CITY OF ALBUQUERQUE

**Re: TLC Pet and Uptown Cat Hospital
1300 Wyoming Blvd NE
Request Permanent C.O. - Accepted
Engineer's Stamp dated: 10-29-14 (J20D027)
Certification dated: 5-27-15**

CITY OF ALBUQUERQUE

**Re: TLC Pet and Uptown Cat Hospitals, 1300 Wyoming Boulevard, N.E.
Traffic Circulation Layout
Engineer's/Architect's Stamp dated 10-06-14 (J20-D027)**

sheet
C001

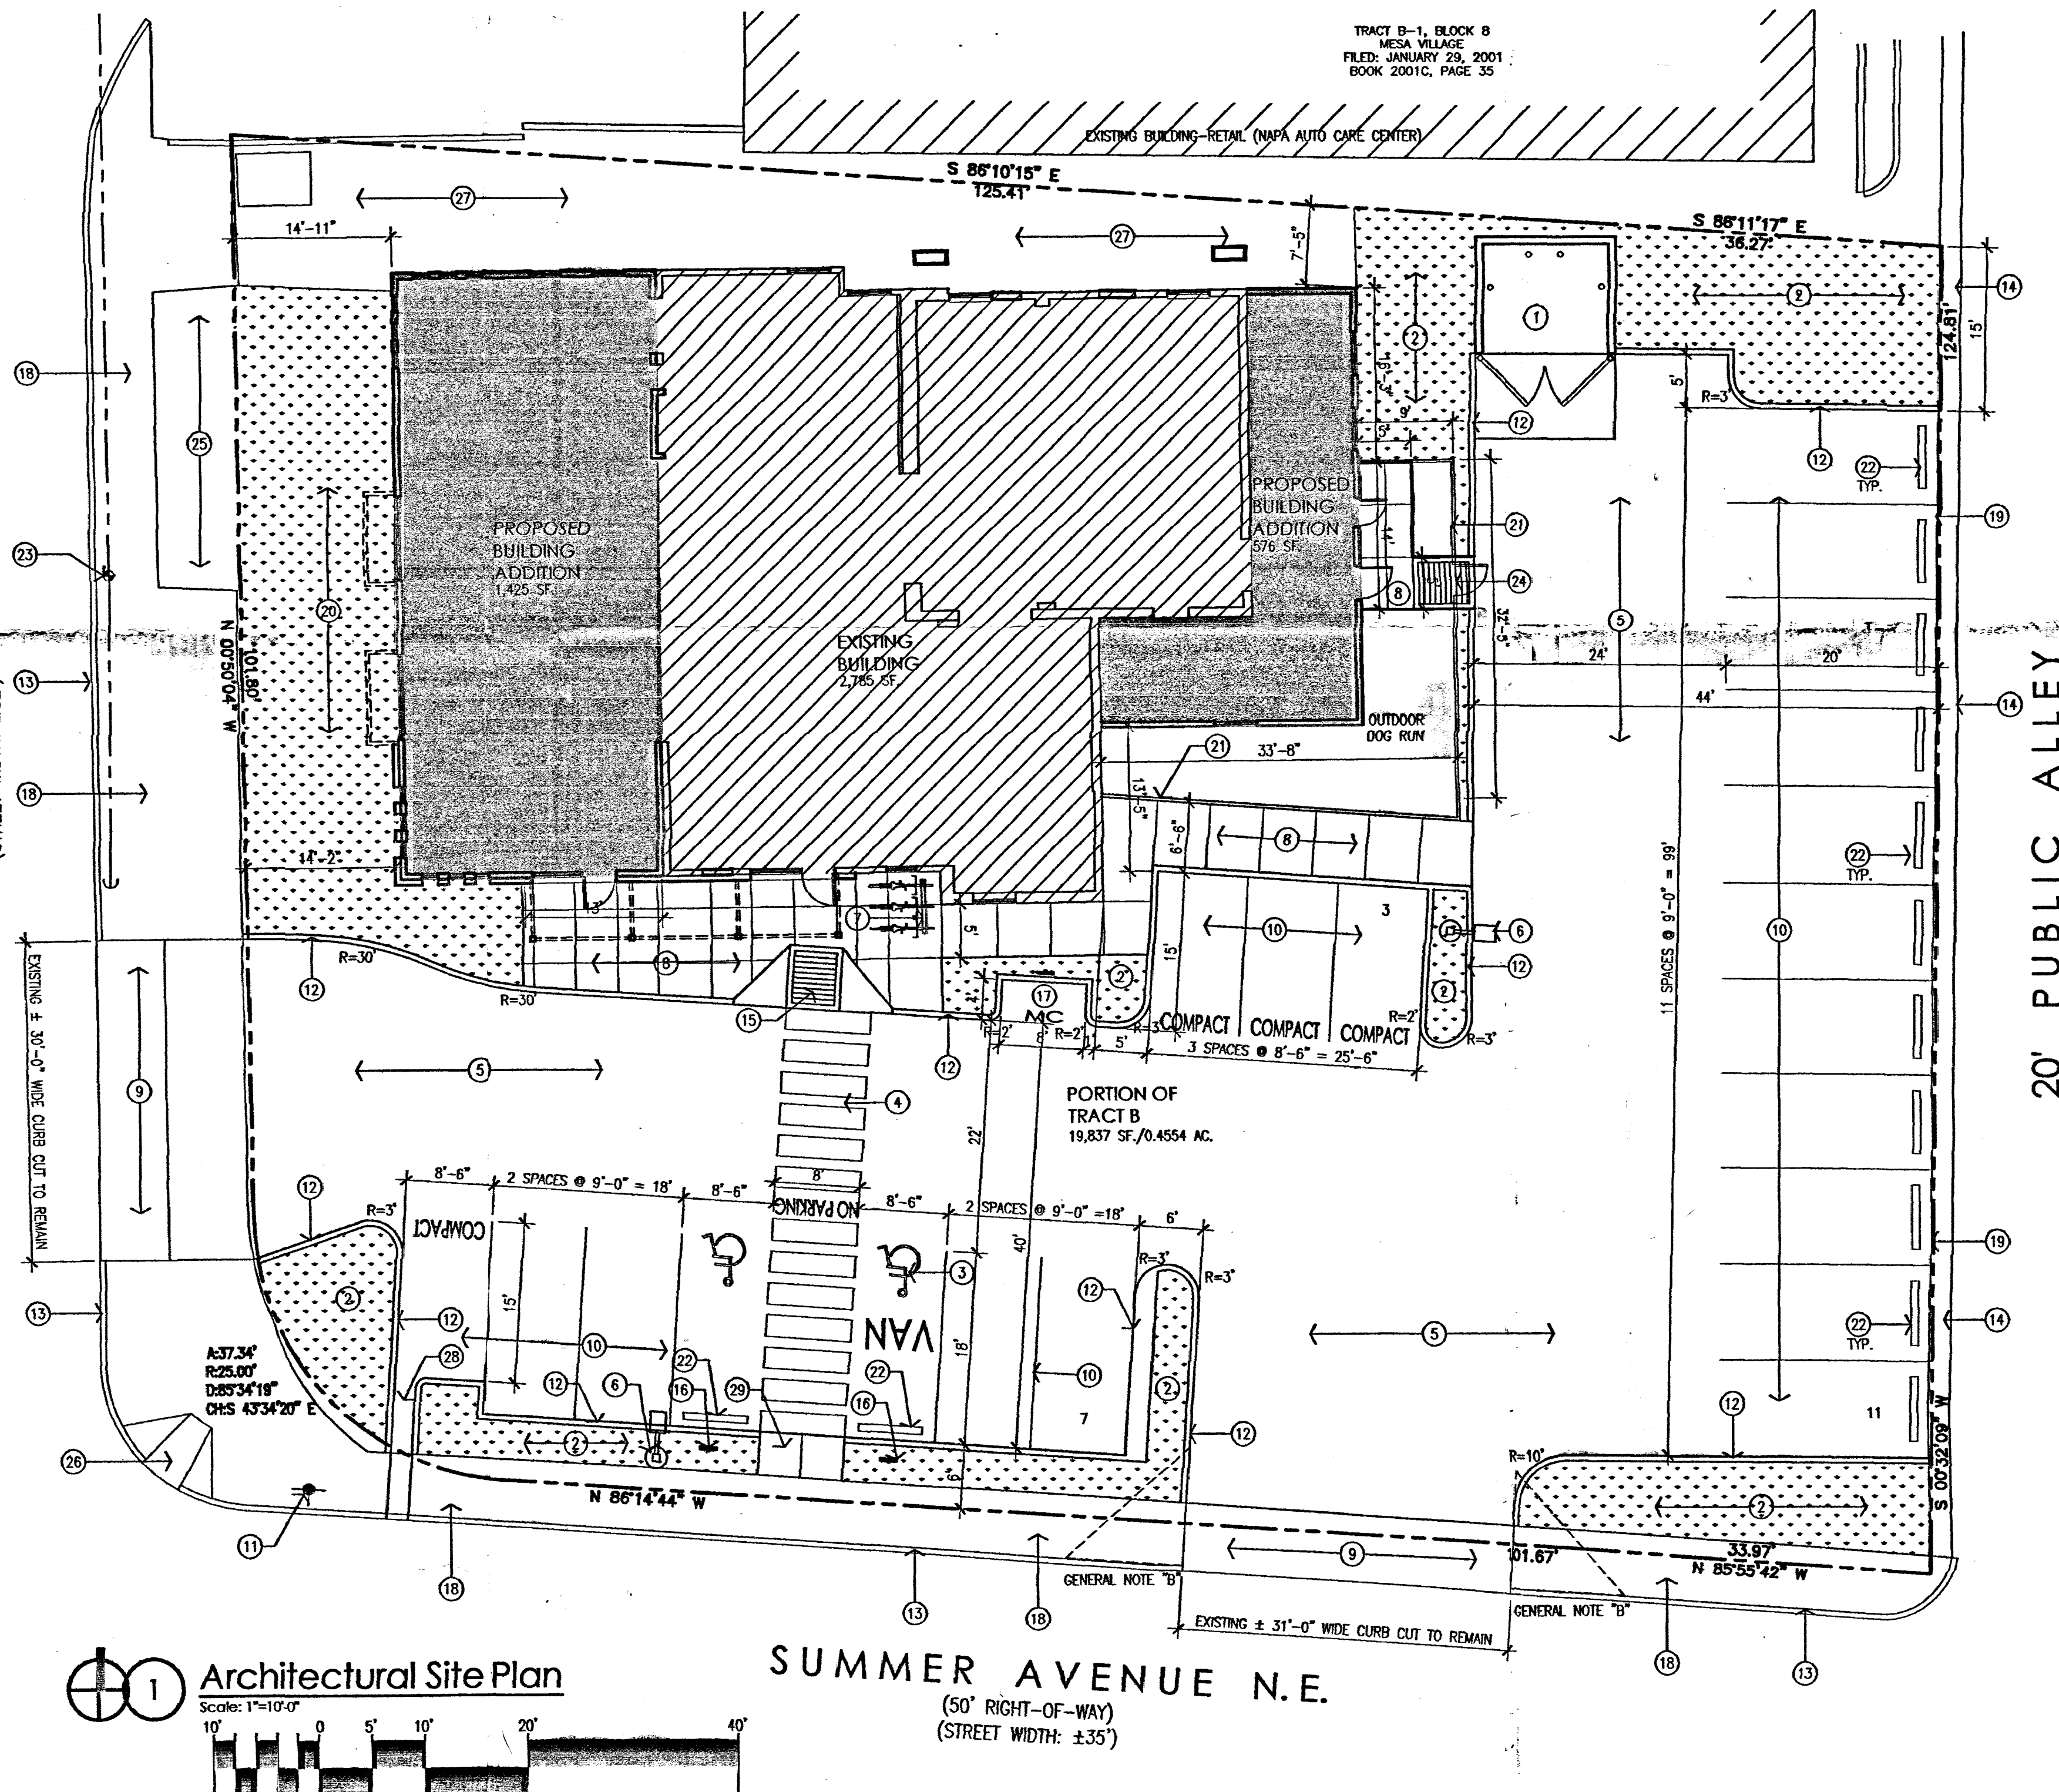
Based upon the information provided in your submittal received October 15, 2014, the above referenced plan is approved for Grading Permit but not Building Permit. Please address the following comments.

1. A S0-19 permit is required for this site because of the sidewalk culvert. The standard language is attached. Add this to the drawing. Also include a signature block for the City Inspector. Request S019 approval with the next submittal in addition to the Building Permit request.
2. The First Flush requirement is 0.34 inch multiplied by the impervious not 0.44 inch as shown on the plan. The 0.44 inch is reduced by 0.1 inch for the initial impervious abstraction in Table A-6 of Section 22 of the DPM. Not as much needs to be retained as stated on the plan.

1 Architectural Site Plan
Scale: 1"=10'-0"

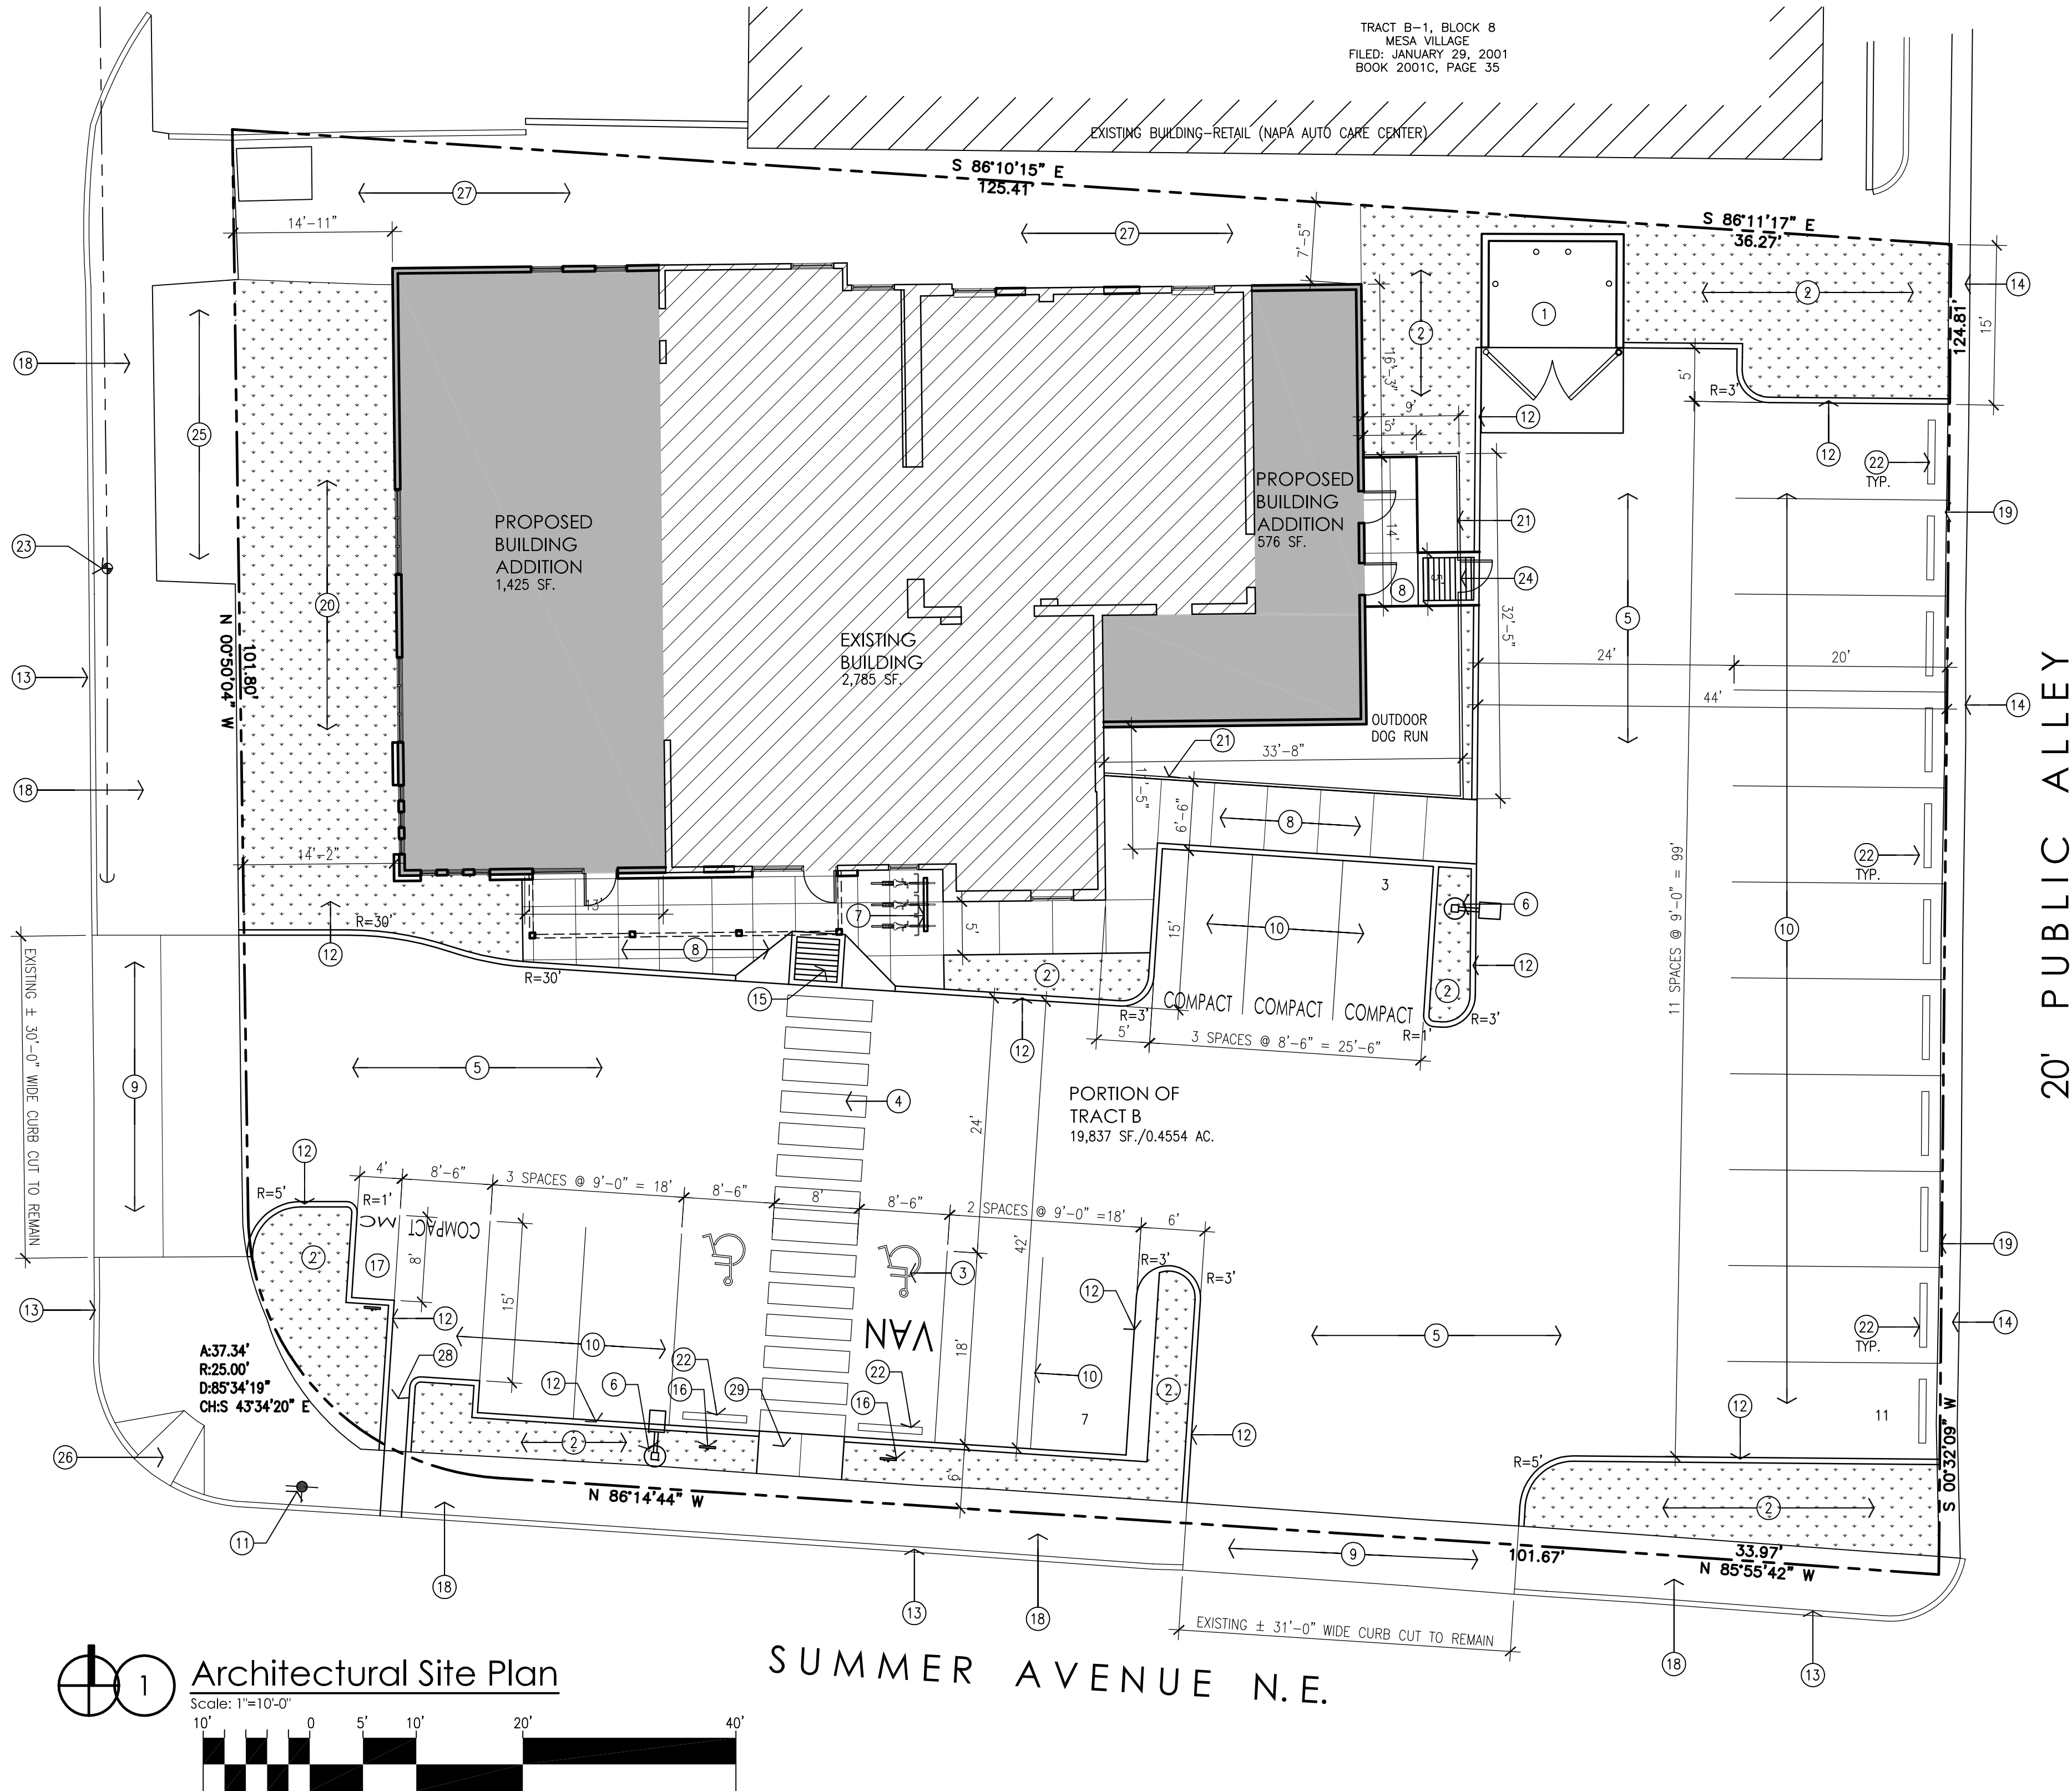
Based upon the information provided in your submittal received 10-07-14, the above referenced plan cannot be approved for Building Permit until the following comments are addressed:

1. Please provide a vicinity map with the location of the site development in relation to surrounding streets.
2. Please provide a legend for the various line-types and hatching.

3. Identify the existing right-of-way width, medians, and street widths for Wyoming Boulevard and Summer Avenue.
4. In addition to being too close to the Summer Avenue intersection, the existing drivepad on Wyoming Boulevard does not match up with the driving aisle. Revise the existing drivepad to match up with the driving aisle along the south side of the access.

5. On the southwest corner of the parking lot, make a correction from "3 Spaces @9'-0" = 18' " to " 2 Spaces@9'-0" =18' ".
6. For Keyed Note 16, the ADA van accessible sign must have the required language per 66-7-352.4C NMSA 1978 **"Violators Are Subject to a Fine and/or Towing."**

7. The ADA access aisle shall have the words **"NO PARKING"** in capital letters, each of which shall be at least one foot high and at least two inches wide, placed at the rear of the parking space so as to be close to where an adjacent vehicle's rear tire would be placed. (66-1-4.1.B NMSA 1978)

8. See Figure 23.7.2 of the DPM for end of parking aisle islands. Change the curb radii from 1 foot to 3 feet where shown on parking aisle islands near the end of

the parking spaces. Curb radii should be 15 feet for passenger vehicle maneuvering.

9. Graphically, it appears that it will be difficult to incorporate a 6-foot wide flat ADA-accessible path in front of the door in addition to a ramp with a 12:1 slope. (Make sure that both the 12:1 ramp and a 6-foot pathway can be incorporated. The ramp is only drawn at a 5-foot length.)

10. Call out curb height for Keyed Note 12. Keyed Note 12 needs to correctly point to curb for access off of Wyoming Boulevard.
11. For ease of refuse vehicle maneuvering, move the refuse at least a few feet to the east away from the curb.

12. Indicate what pavement thickness will be used for the parking lot.
13. The proposed landscaping at the access off of Summer Avenue may interfere with the sight distance. Provide clear site triangle. (See DPM Manual Page 23-74 of the DPM for Mini Clear Site Triangles for Driveways.)

14. Please add the following note to the clear sight triangle: "Landscaping and signage will not interfere with clear sight requirements. Therefore, signs, walls, trees, and shrubbery between 3 and 8 feet tall (as measured from the gutter pan) will not be acceptable in this area."

15. Please specify the City Standard Drawing Number when applicable.
16. Work within the public right of way requires a work order with DRC approved plans.
